Our Ref: JAH/SH

21st November 2011

re. **Town & Country Planning Act 1990**
Application ref: P/87/11
52 East Front Road, Pagham
Proposed extension to existing dwelling
Re-submission following Application P/47/11

Project	52 EAST FRONT ROAD, PAGHAM, BOGNOR REGIS WEST SUSSEX PO21 4ST	Drawn	sk	Project	126
For	Mr and Mrs Eysers	Scale	1:100 @ A3		
Title	SOUTH ELEVATION - PROPOSED 2011	Date	25.10.2011	Revision	d
				Drawing No.	P 06

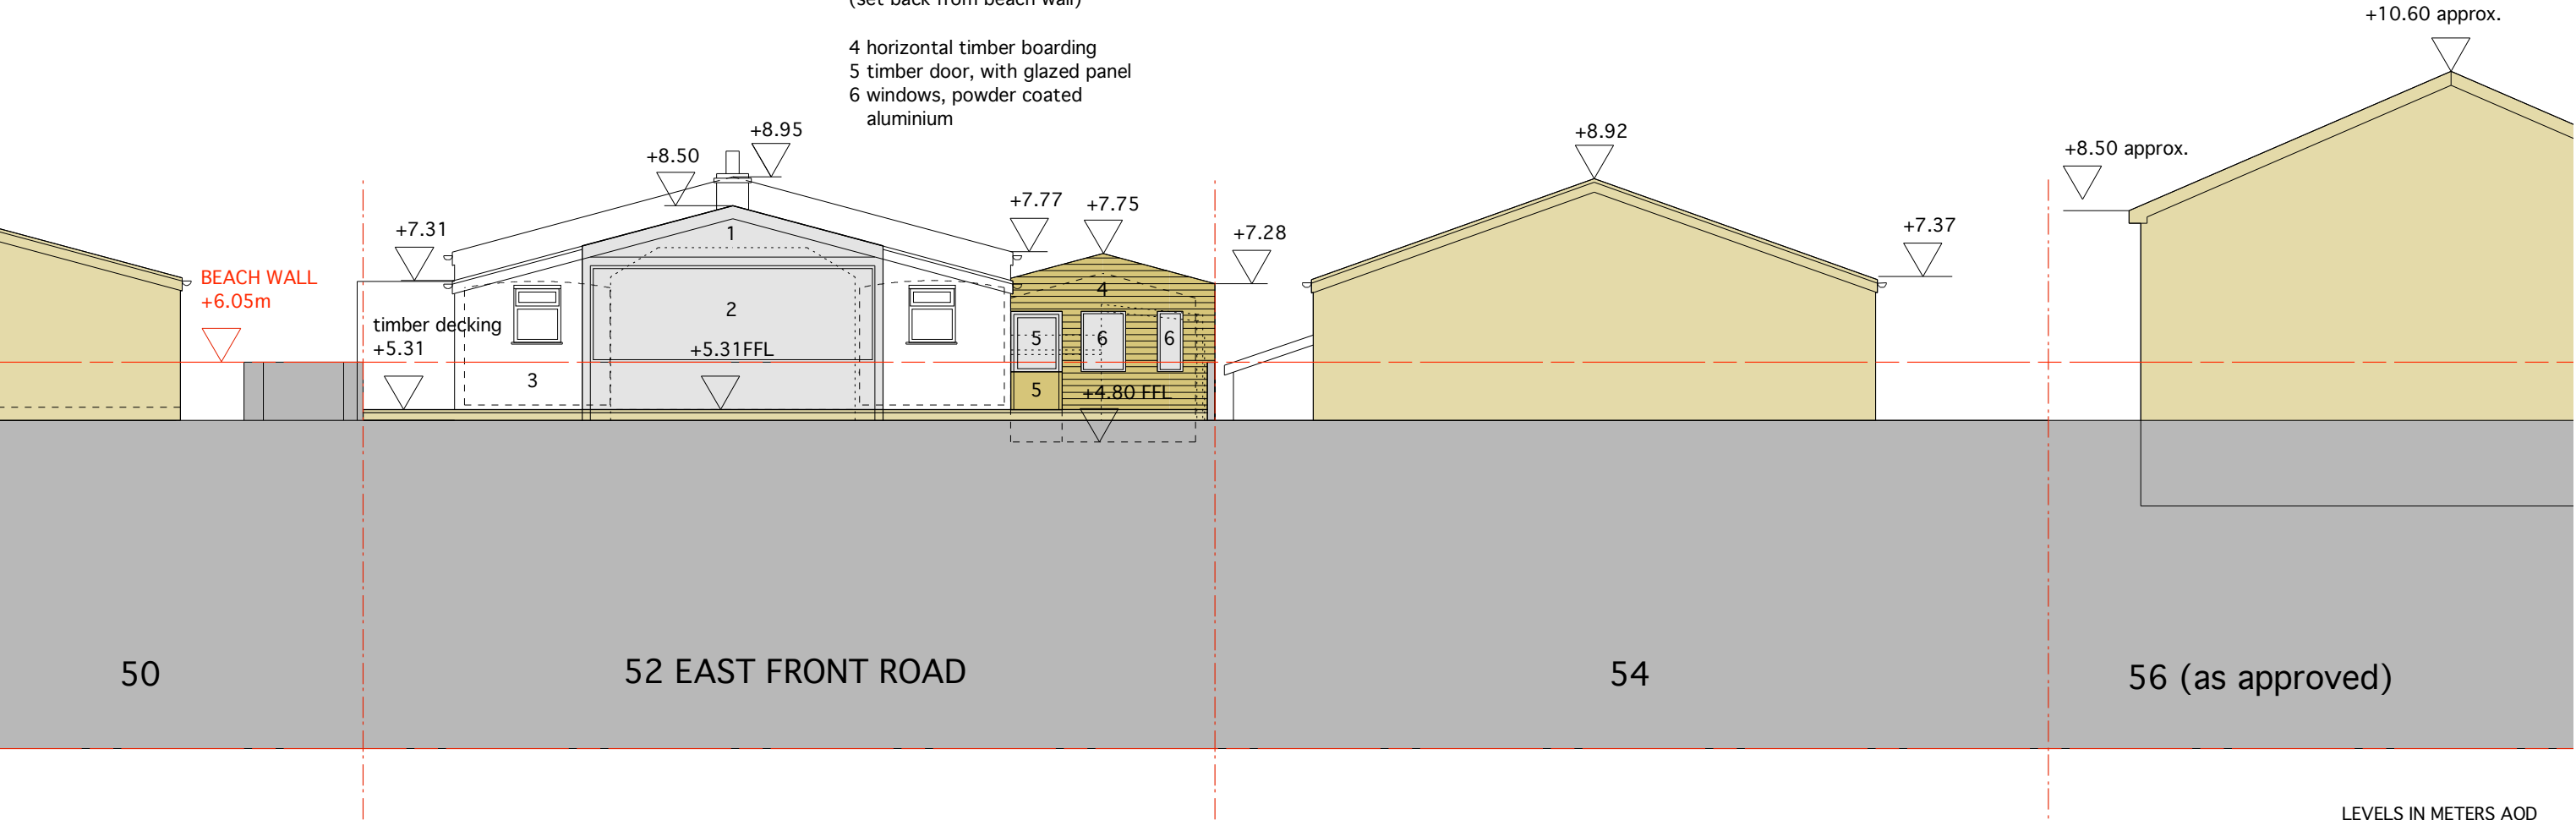
Despite amendment the proposed extension to the north of the original building remains a two-storey structure of basement and elevated ground floor accommodation, and proposes a structure of considerable bulk which it is hoped the Planning Authority would consider unacceptable within the street scene. The two-storey construction is also contrary to Local Plan Policies for the Beach Estate, and if Approved will create an unwelcome precedent.

As a result of the considerable bulk of the building proposed it is also likely to create a serious overshadowing of the dwellings to the west, which again is unacceptable. In general the development is un-neighbourly and should be Refused by the Planning Authority.

Project	52 EAST FRONT ROAD, PAGHAM, BOGNOR REGIS WEST SUSSEX PO21 4ST	Drawn	sk	Project	126
For	Mr and Mrs Eysers	Scale	1:100 @ A3		
Title	EAST ELEVATION AND SECTION A-A - PROPOSED	Date	25.10.2011	Revision	d
					Drawing No. P 07

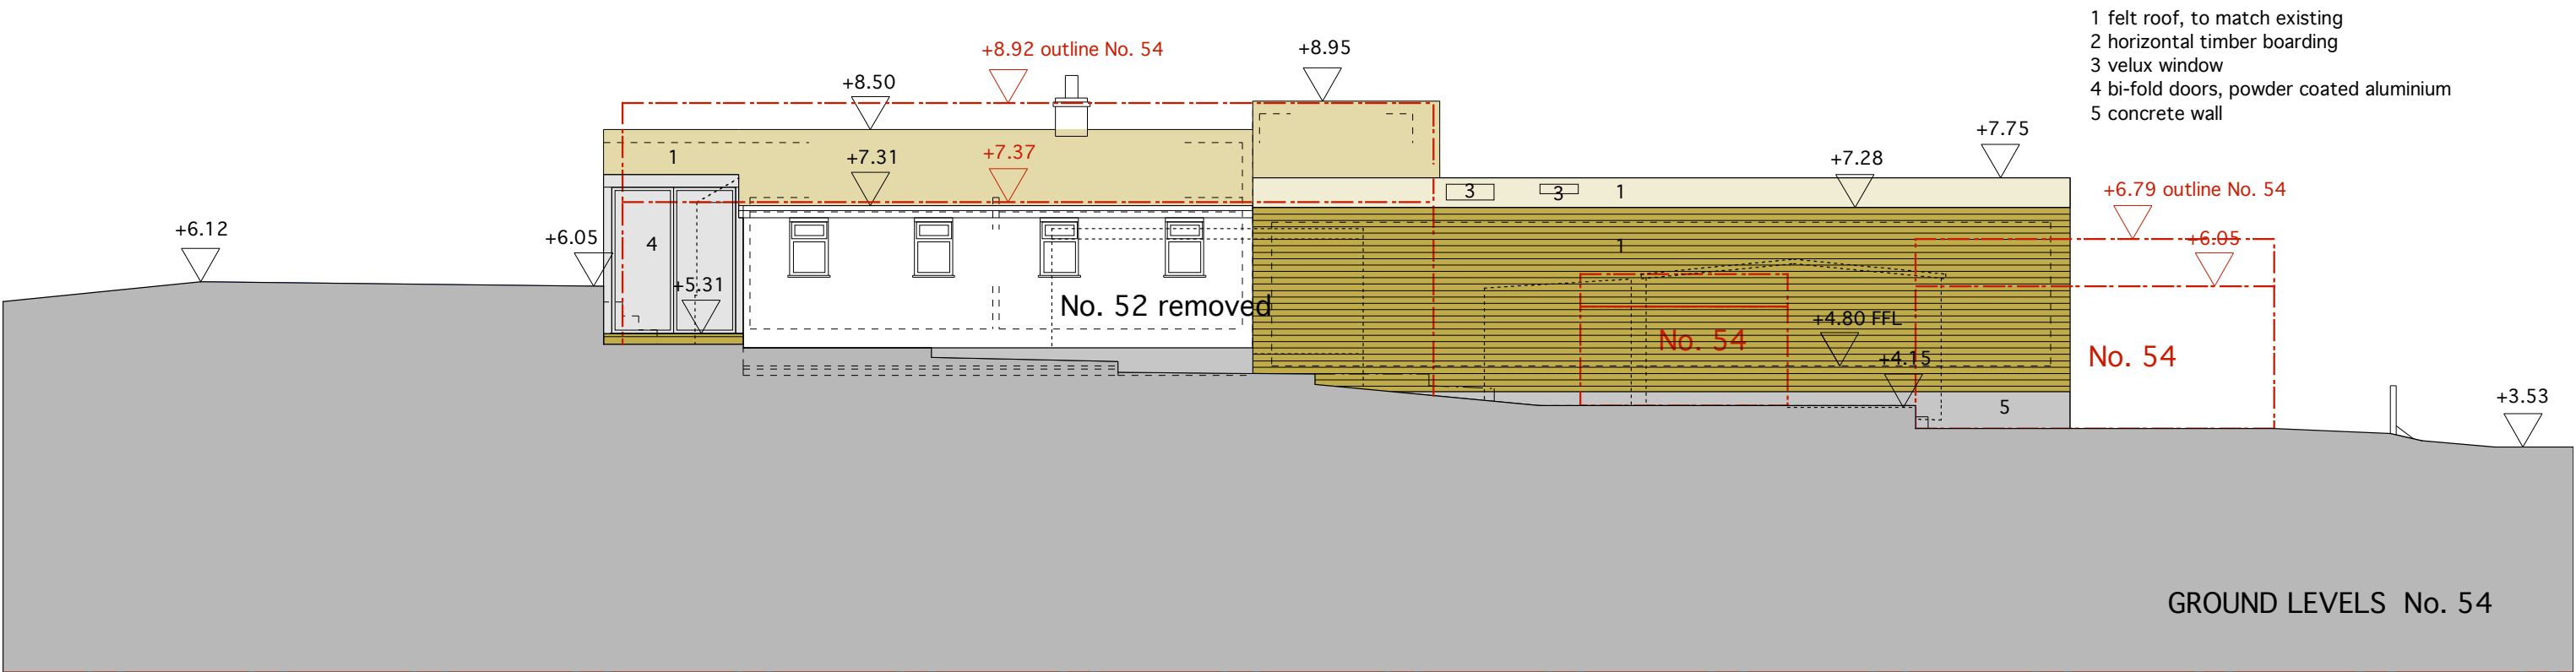
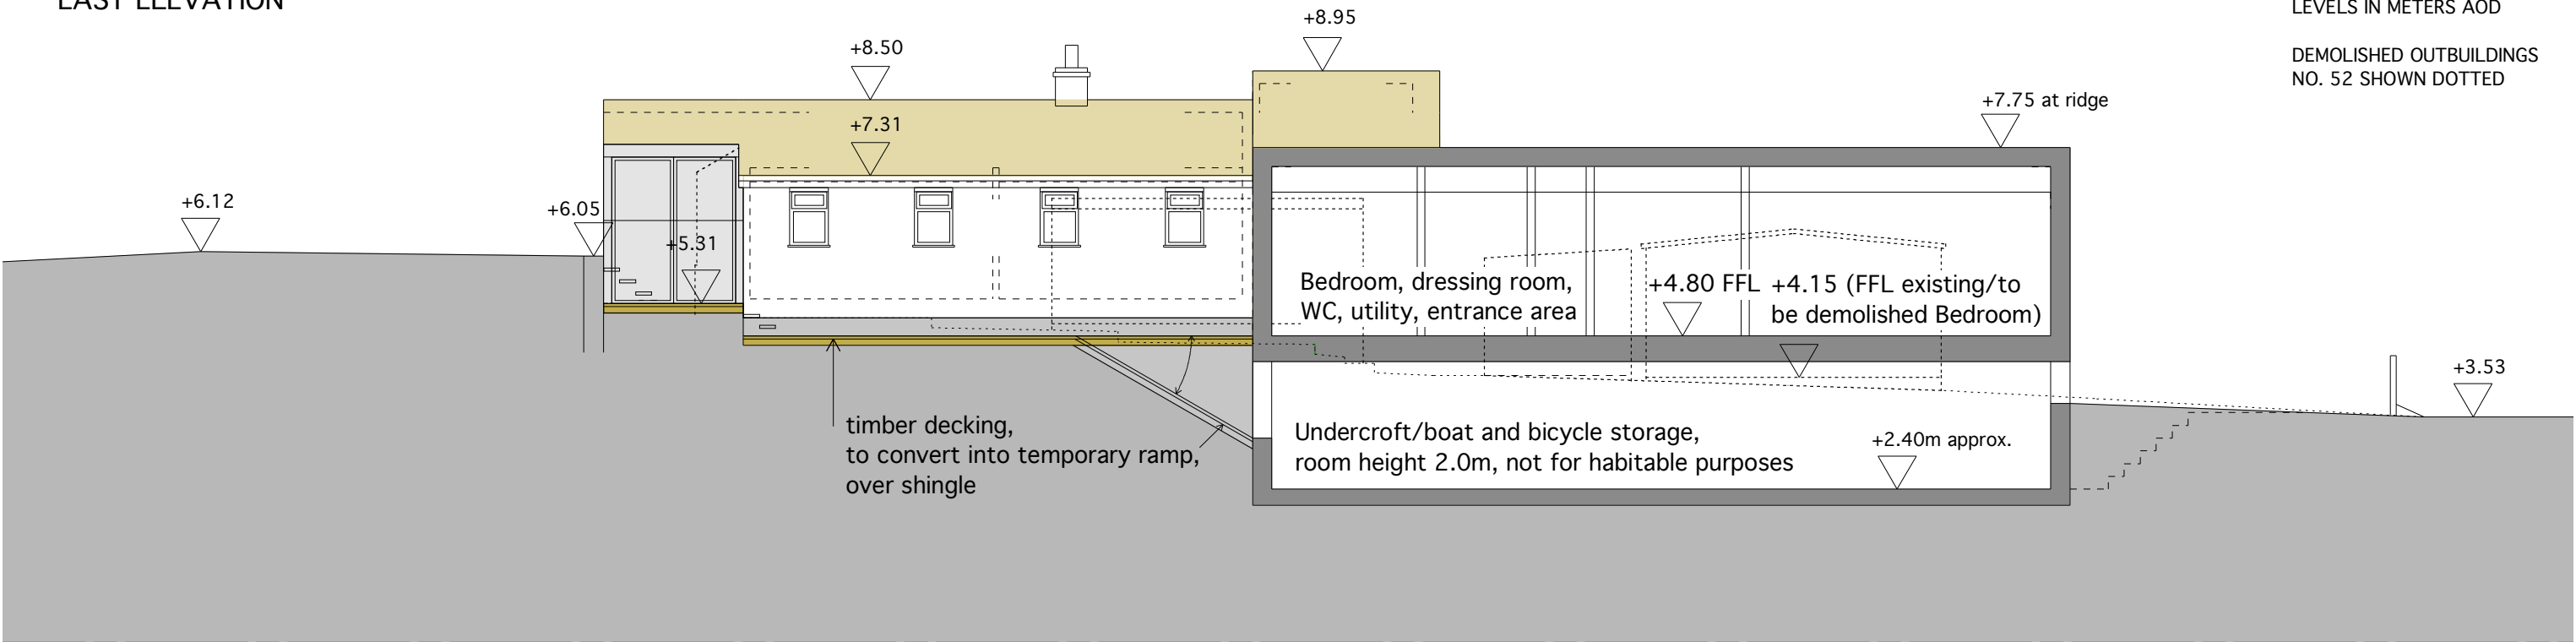
The formation of a basement with a finished floor level as defined, proposed at 2.74 OAD is over 3.000 (10'0") below existing levels on the adjoining beach foreshore. This is completely inappropriate in this location and in the opinion of the Directors is verging on downright dangerous.

In order to achieve the construction at this depth, excavations to a depth of 12'0"-14'0" below beach level must be created, which in the shingle sub-strata will cause considerable local disturbance. The adjoining site and bungalow to the east must be protected and maintained stable and as a consequence a substantial retaining wall would need to be constructed on the boundary, to prevent collapse of the adjoining structure. These extensive civil works will be extremely damaging adjacent to a shingle foreshore already threatened by erosion from wave action and must be considered unwise and inappropriate.

The arrangement of the basement boathouse with a ramp down from the foreshore will definitely result in basement flooding with any over-topping event on high tide and/or storm conditions. This arrangement must surely be considered a completely unsuitable proposal which could endanger adjoining properties.

It should also be noted that the scheme proposes the installation of rooflights within the roof construction, which again is contrary to Local Plan Policies for the Beach Estate, and if allowed will create a precedent, which will undermine the Planning Authority's policies.
